Little Crow Solar Park, Scunthorpe

**APPLICANT'S RESPONSE TO THE SCHEDULE
OF THE EXAMINING AUTHORITY'S
RECOMMENDED AMENDMENTS TO THE
APPLICANT'S DRAFT DEVELOPMENT CONSENT
ORDER**

Schedule of the Examining Authority's ("ExA") recommended amendments to the Applicant's draft DCO version F [REP6-003]

**Schedule of ExA's recommended amendments to the Applicant's
draft DCO version F [REP6-003]**

WORKS DETAILS - KEY A3 - SHEET 3 OF 7

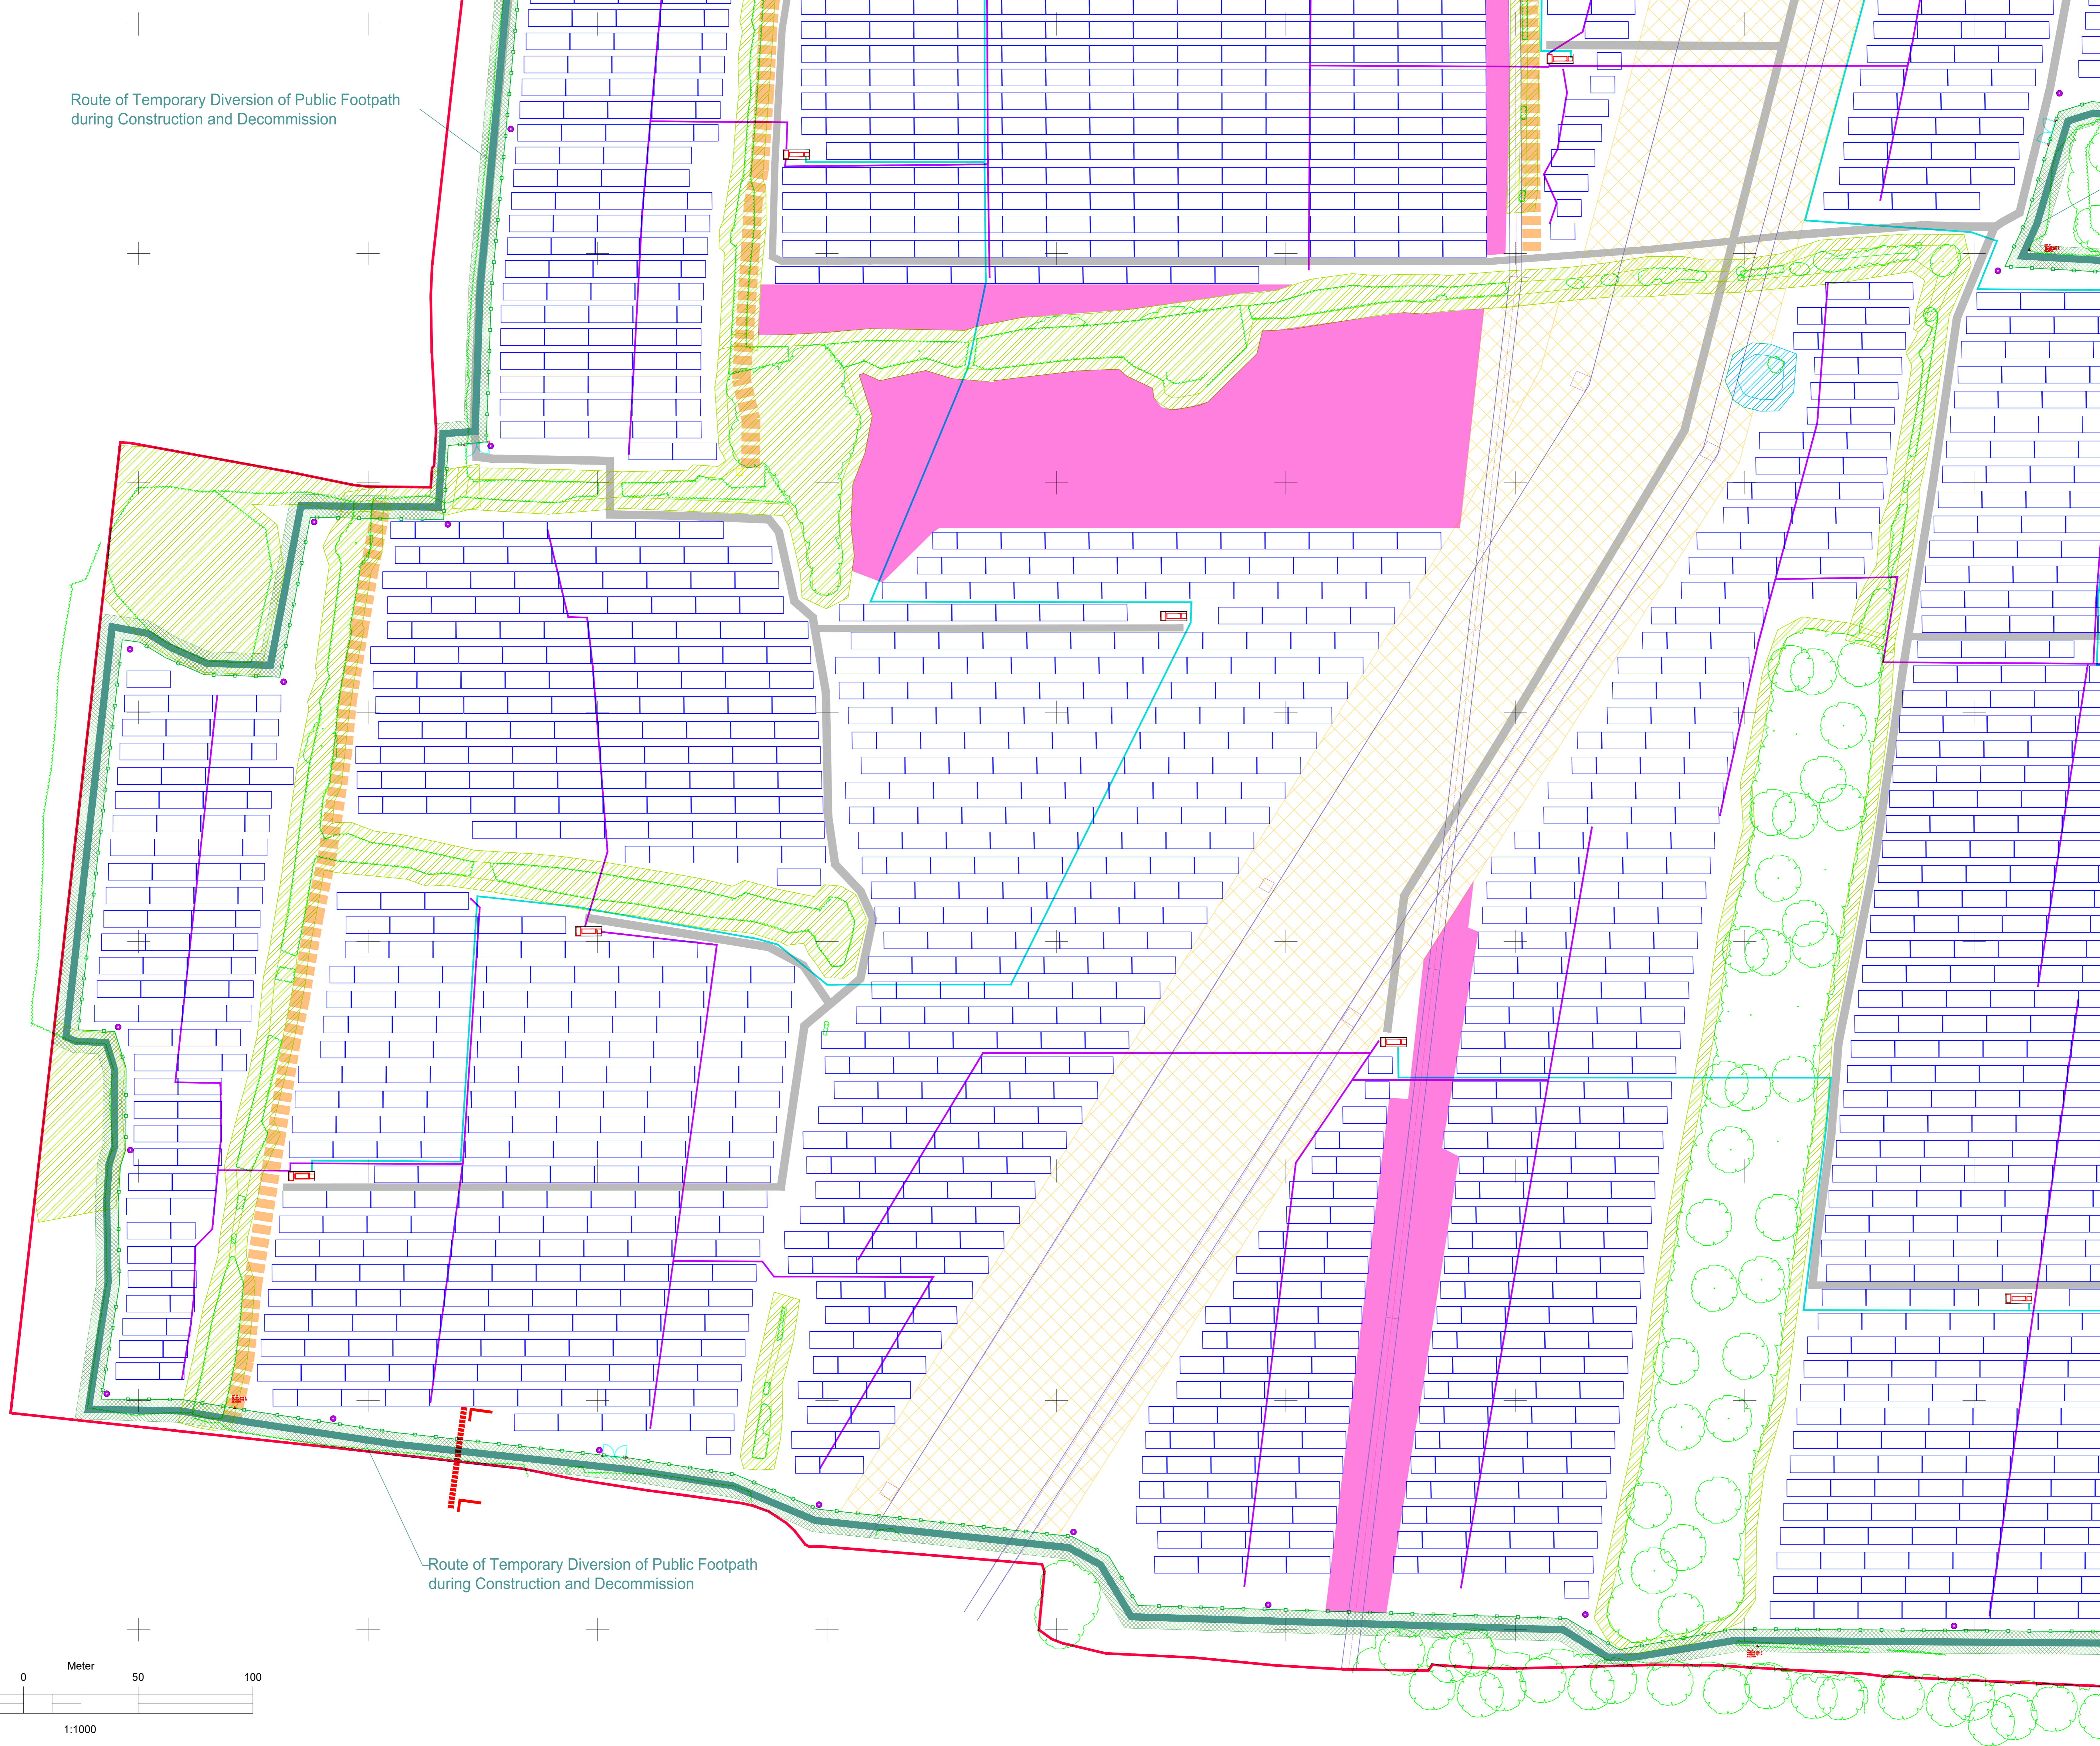
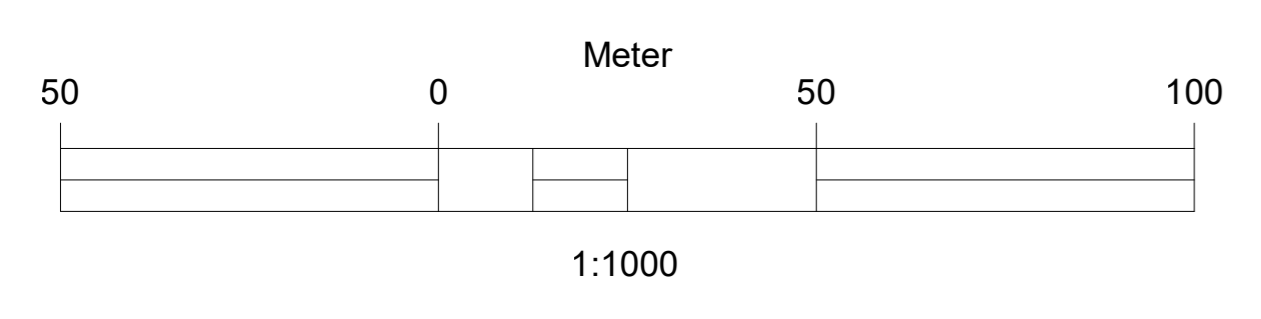
... the appointed person must have regard to relevant the guidance on costs in the Planning Practice Guidance website or any official circular or guidance which may from time to time replace it.		.
Schedule 3 Public footpath to be temporarily closed and diverted			
Column 2 in Table 1	'Drawing P17-0718-30 D REV G 1 – PROW (document reference 2.39 LC DRW)	The version of the plan submitted by the Applicant with its application showing the proposed temporary diversion of public footpath 214 appears to be a revision G 1 or G I rather than D [Examination reference APP-043 and application document 2.39]	The Applicant agrees that the Drawing Reference should be P17-0718-30 REV G 1 rather than P17-0718-30 REV D. The Applicant has amended the reference in column 2
Column 6 in Table 1	'From A-D-C-B A-C-D-B as shown with a dashed black line ...'	The letters C and D appear to have been transposed in Column 6 when compared with the lettering shown on the footpath diversion plan [APP-043].	The Applicant agrees that the letters C and D were transposed and has corrected this in column 6 of Schedule 3.
